OBJECTION

Application Reference 6/2021/2752/VAR
Variation of Condition 18 (revised layout) on planning permission 6/2019/2752/VAR

Drawing Title: Proposed Elevations 1 of 2

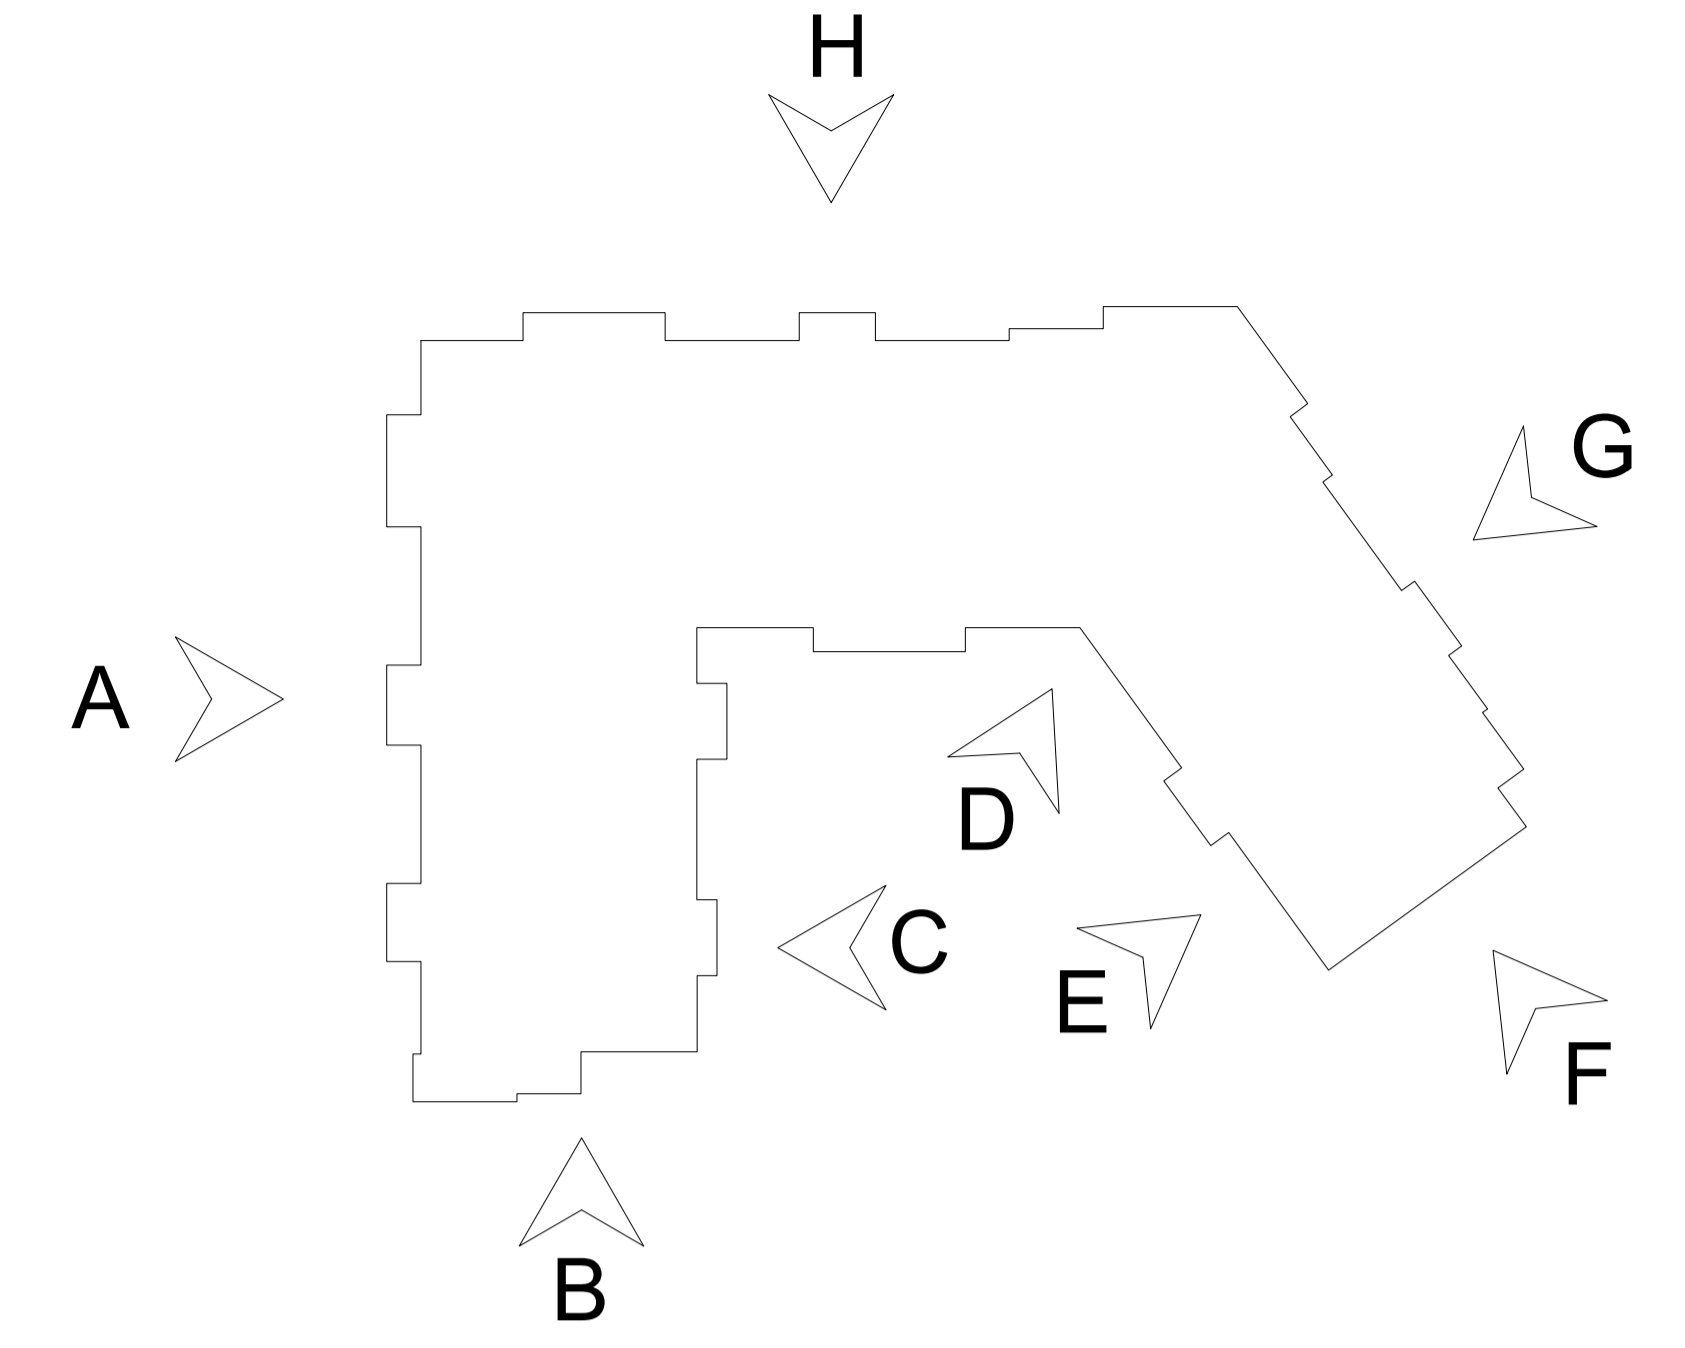
Further to your letter dated 4th October we are writing to register our objections to the above variation to the building work taking place on Manor Road, which has moved Tank Room, Plant Room, Laundry and kitchens to the North elevation.

Item	Comment	Strongly Object	Object	Don't Mind
1. Tank Room on North Elevation	Apart from potential noise, looking at the plans it seems to raise the roof line up.	✓		
2. Plant Room on North Elevation	Continuous noise from boilers, pump, air handling and other mechanical machinery.	✓		
3. Laundry on North Elevation	Again, continuous noise, from machines and driers	✓		
4. No balconies on North Elevation,	These would have broken up wall and be more pleasing to the eye	✓		
5. Kitchen now on 1 st floor of North Elevation facing Manor Rd	This will cause smells and noise from extractors towards the houses on Manor Road, plus noise from deliveries	✓		
7.				
8.
